Charlotte Storm Water  
600 East Fourth Street  
Charlotte, N C 28202-2844

## Rezoning Petition Review

**Rezoning Petition #:** 20-145

**Location of Property:** Approximately 18.95 acres located along the north side of Marvin Rd, the west side of Johnston Rd and south of Providence Rd West.

TECHNICAL DATA SHEET

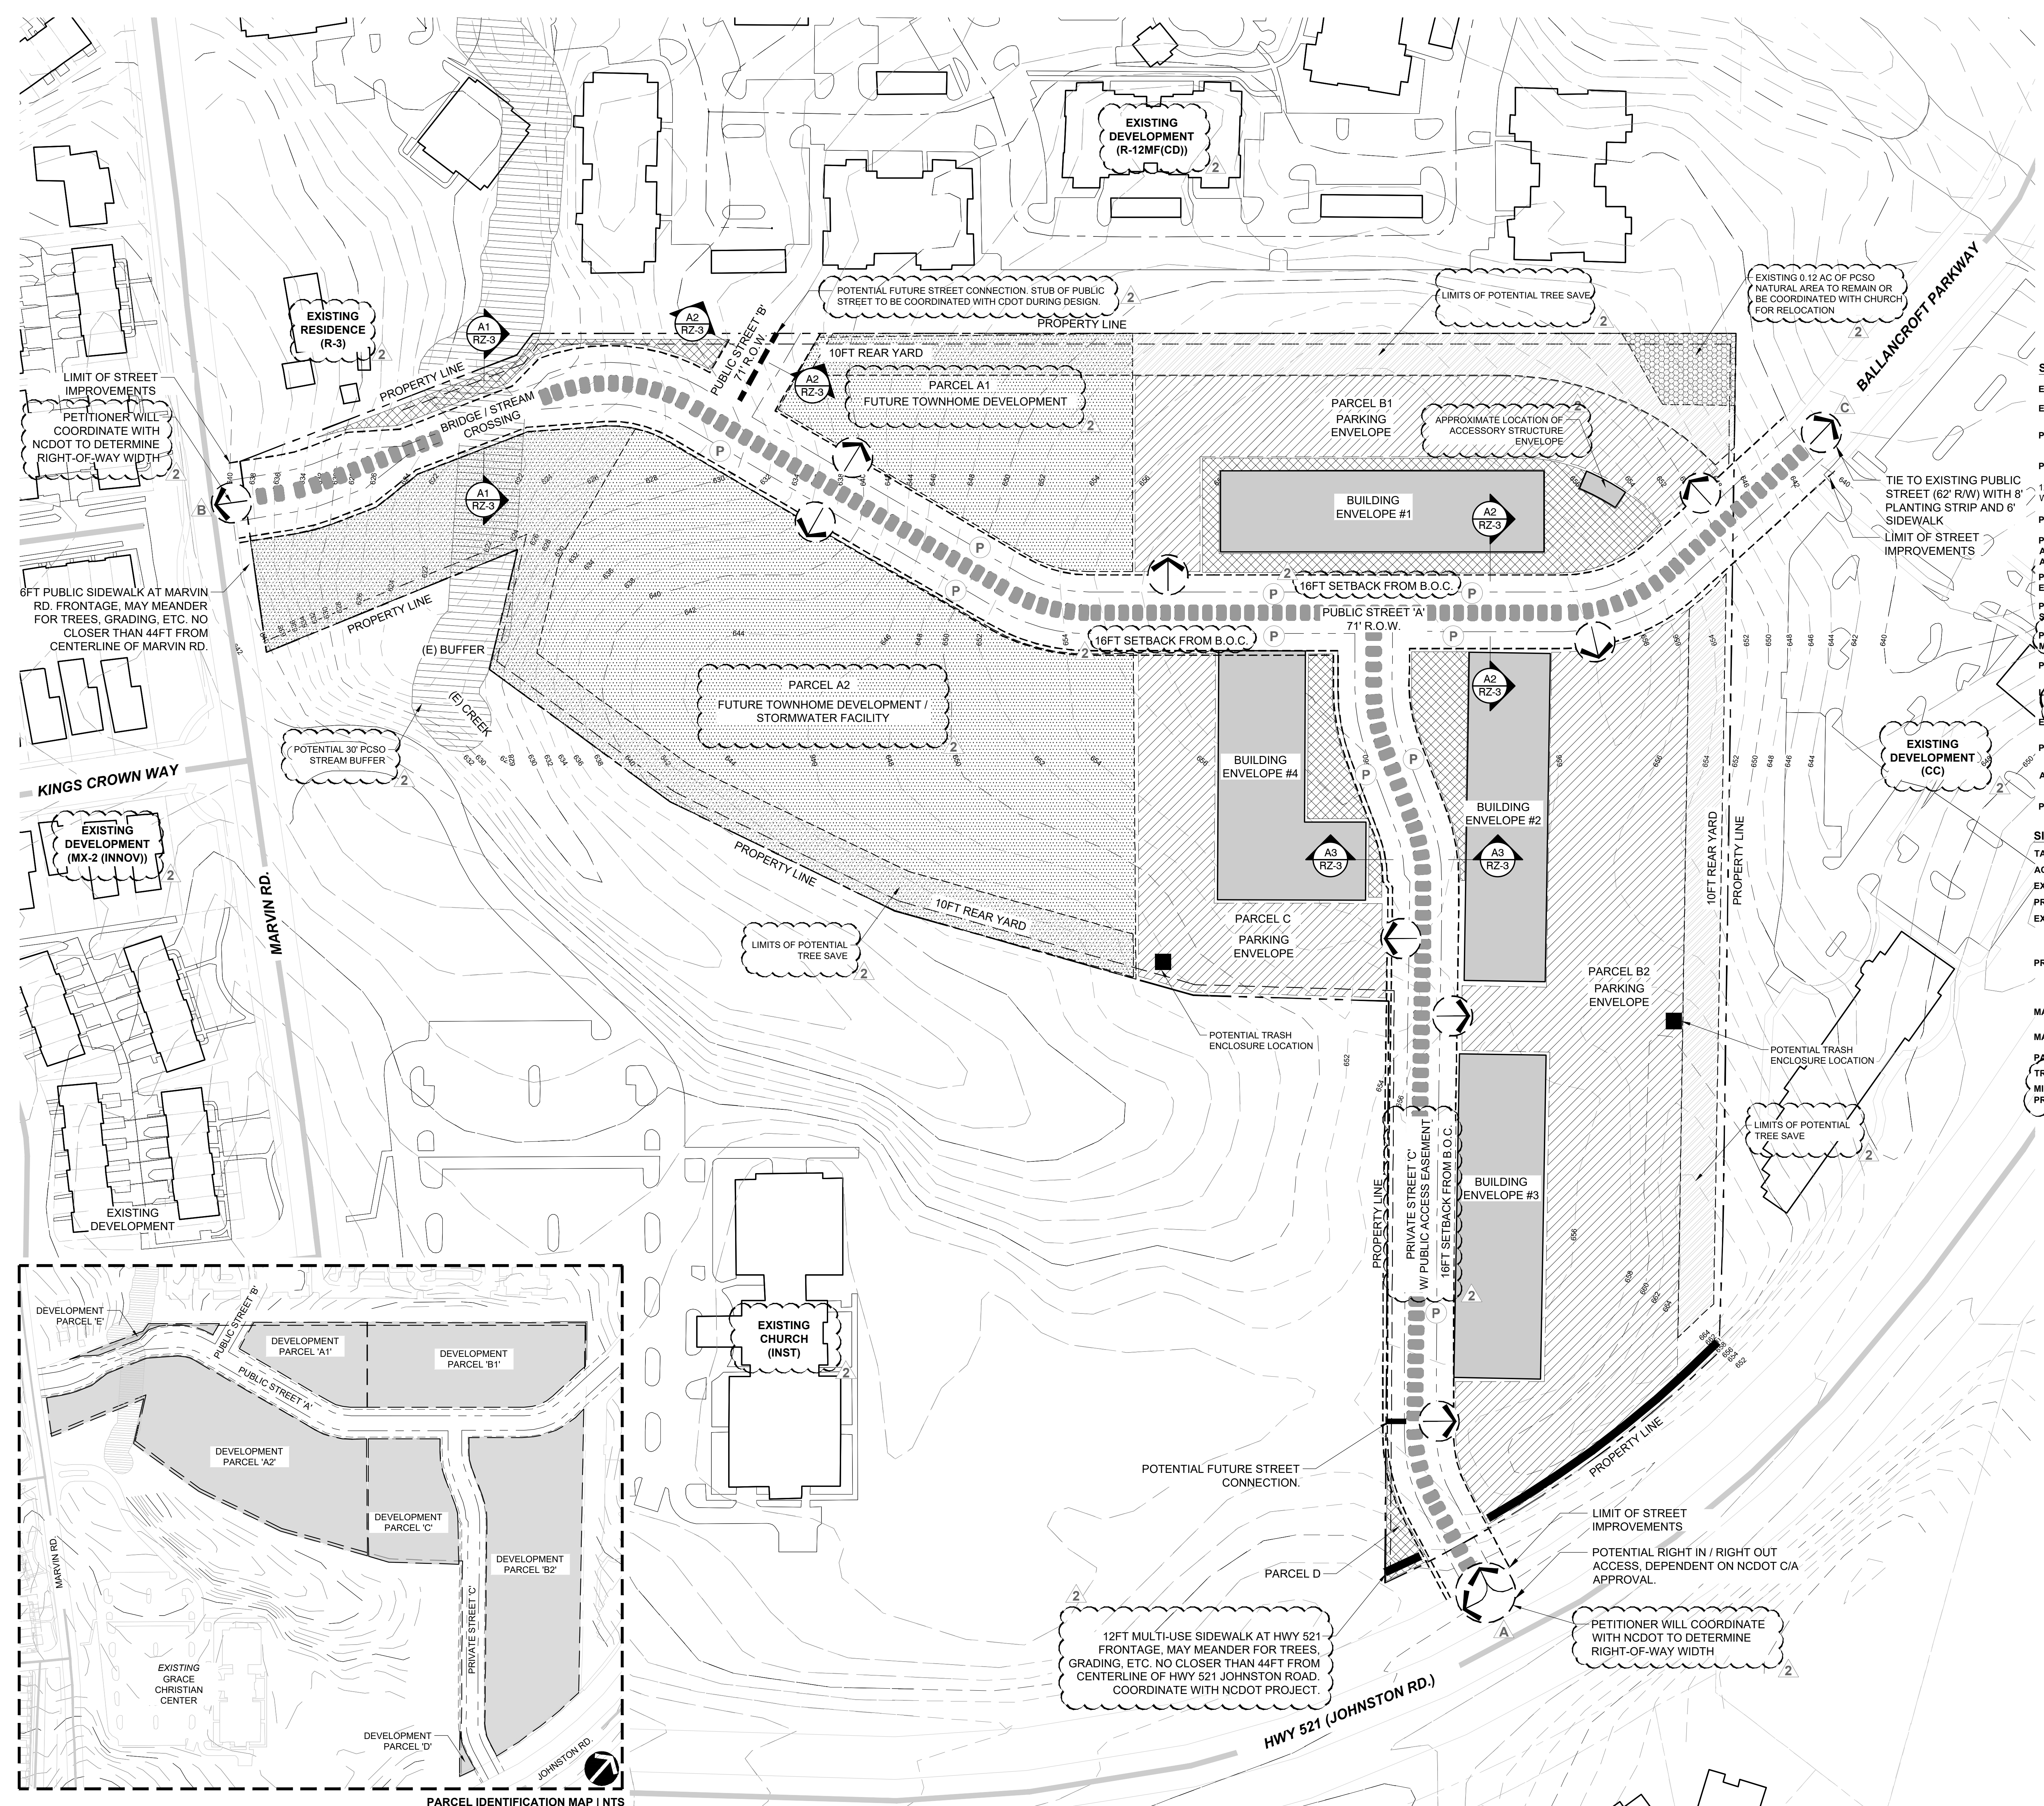
**Concerning Storm Water:** Charlotte GIS indicates a 30-ft PCSO Buffer on site. Please revise the callout labeled "(E) BUFFER" to "Potential 30-ft PCSO Buffer". Any increase of impervious area within such buffers may not be allowed and is not approved with the rezoning process. Please include the following note under Environmental Features: *"Development within any SWIM/PCSO Buffer shall be coordinated with and subject to approval by Charlotte-Mecklenburg Storm Water Services and mitigated if required by City ordinance. Petitioner acknowledges intermittent/perennial stream delineation reports are subject to review and approval upon submission of development plans for permitting and are not approved with rezoning decisions."*

Please note the proposed street connection to Marvin Road potentially crosses an existing storm water detention facility for the Grace Christian Church. Coordination may be necessary for any modifications needed for the church site to maintain compliance with City storm water regulations.
